US-24G (E-X) / Woodmen Road  
El Paso County

January 16, 2025

RE: The Commons at Falcon Field Filing No. 1 (SF2435)

LEGEND

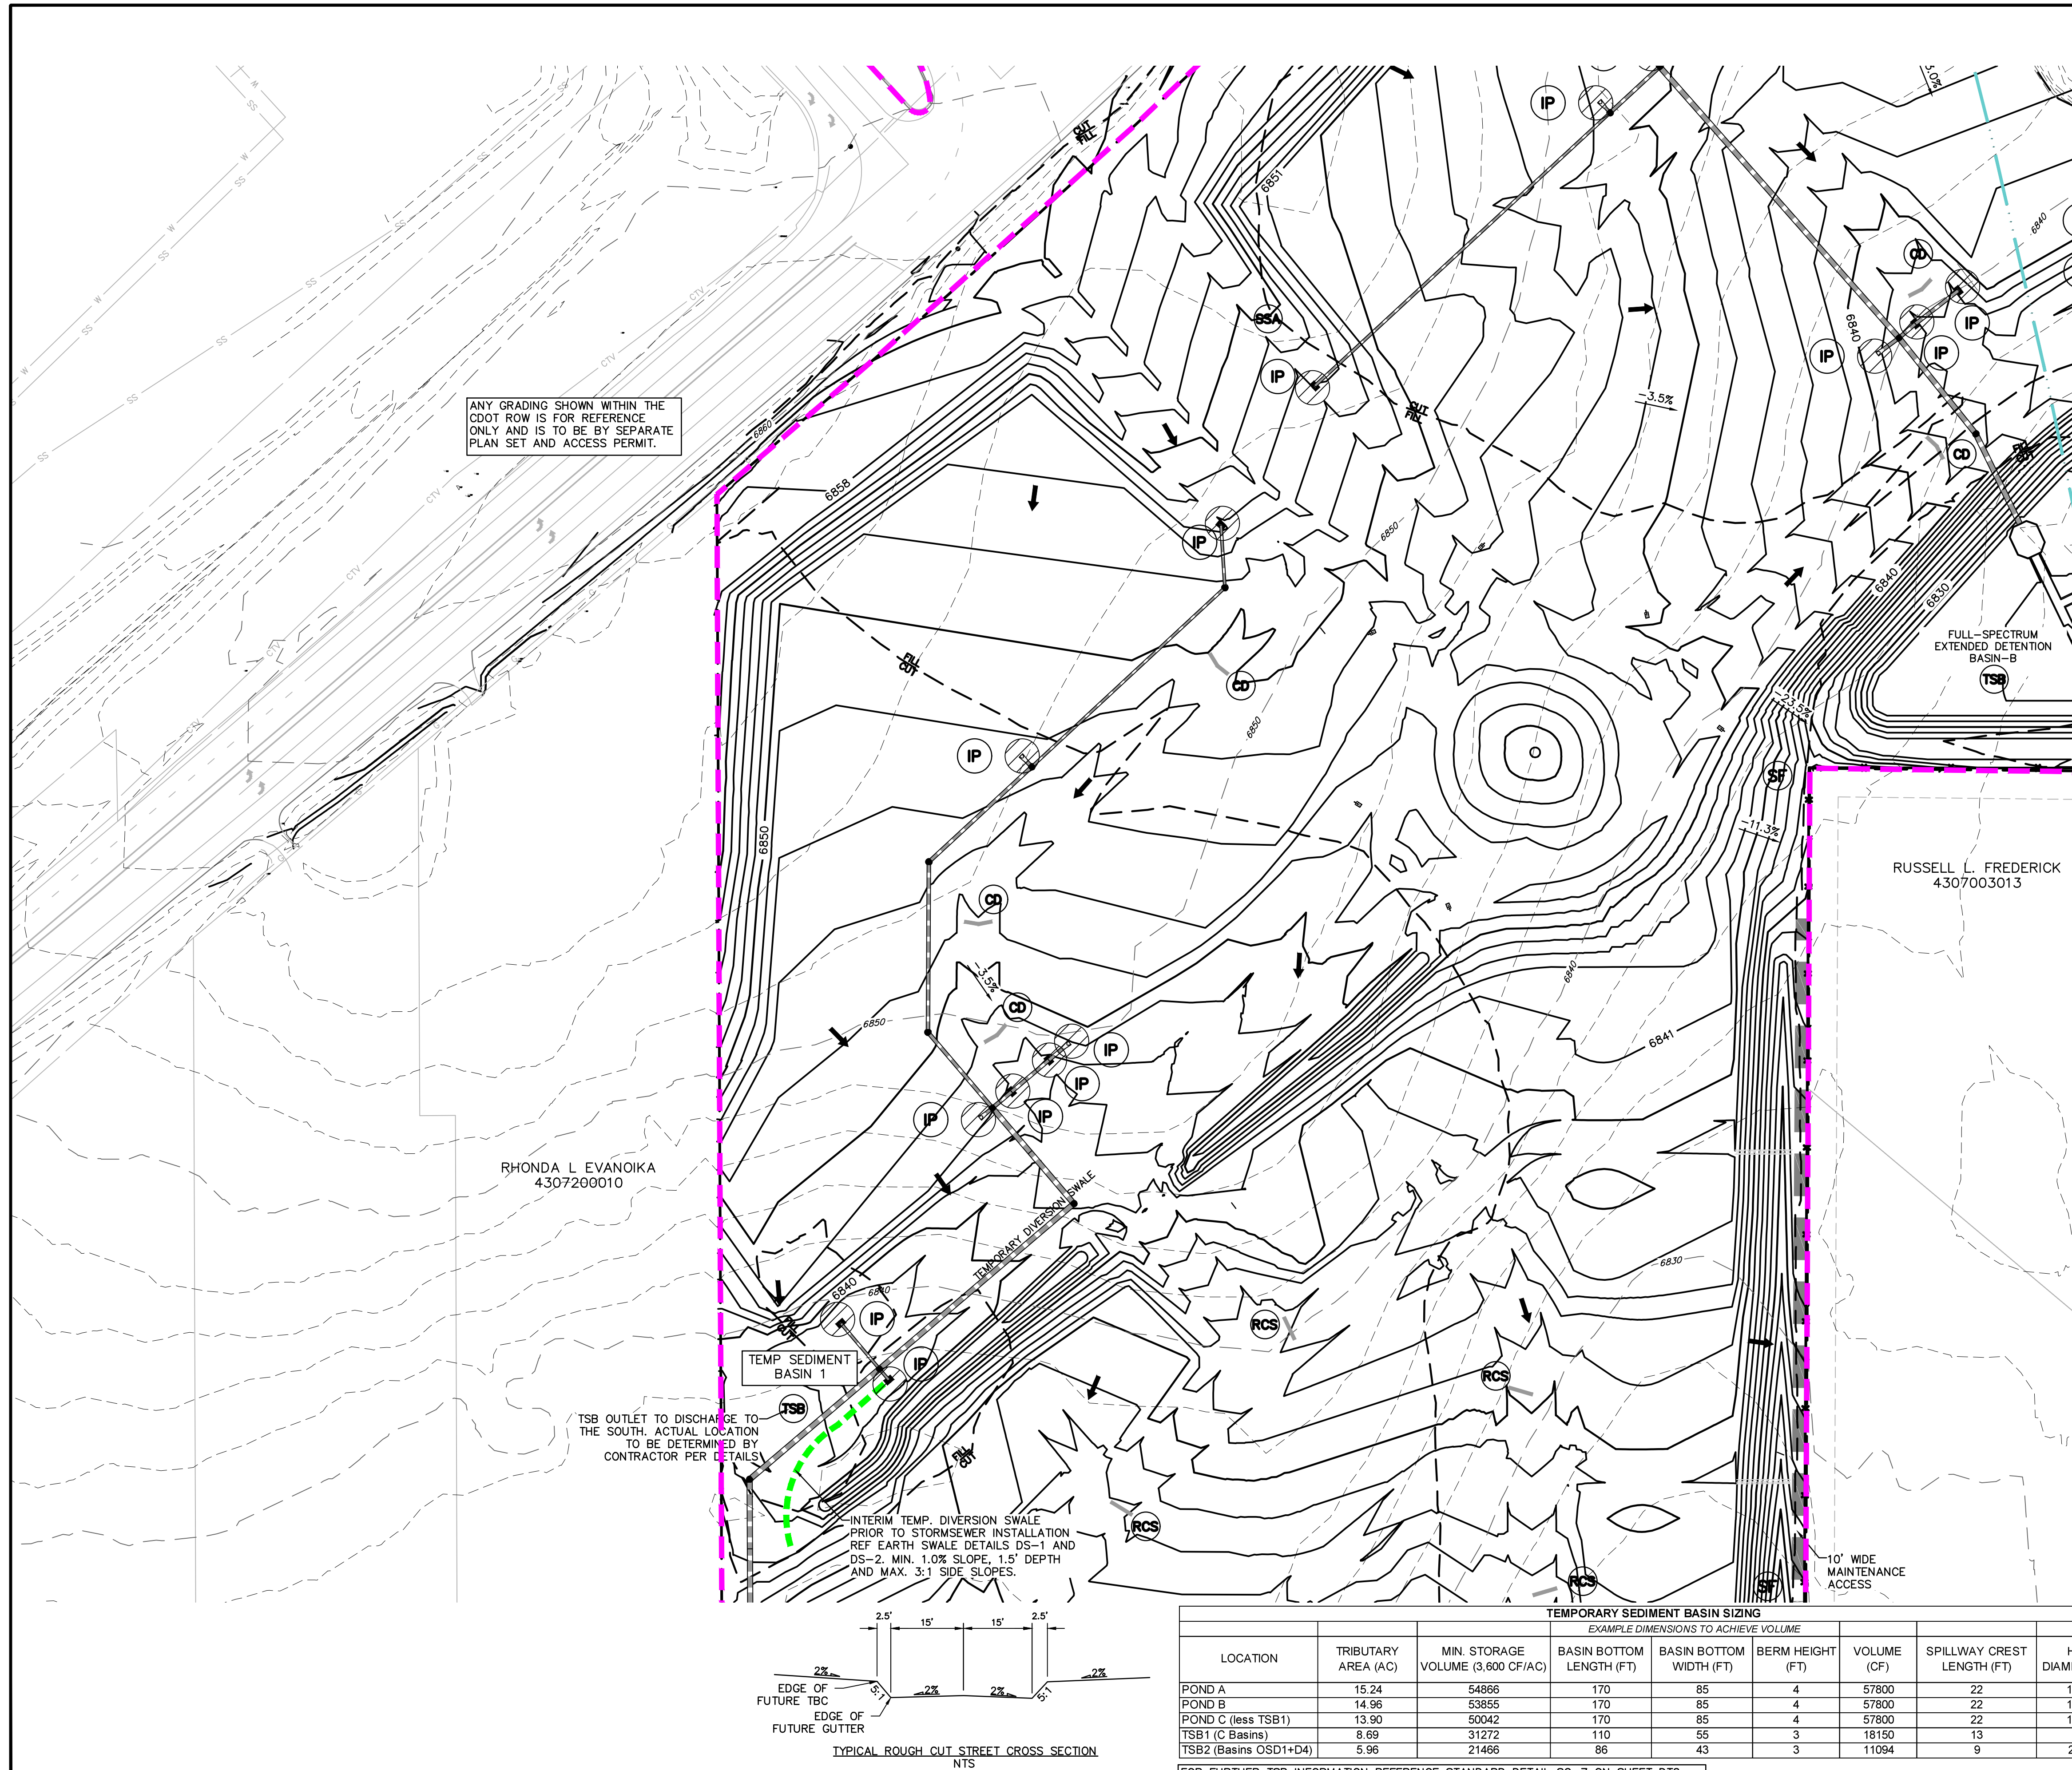
- Plan comments:
  - The grading plans show work to be completed within CDOT right-of-way, but the landscape plans only call for vegetated areas within the project limits.
  - **Verify that the graded areas shown in the GEC plans will be vegetated.**
- Report comments:
  - Is there adequate capacity in the proposed roadside ditches along US-24? Calculations were not included. The grading suggests the ditch is approximately 1' deep.
  - As the grading of the roadside ditches lies within CDOT right-of-way, the capacity should be confirmed for the ultimate condition of the widened US24 section.
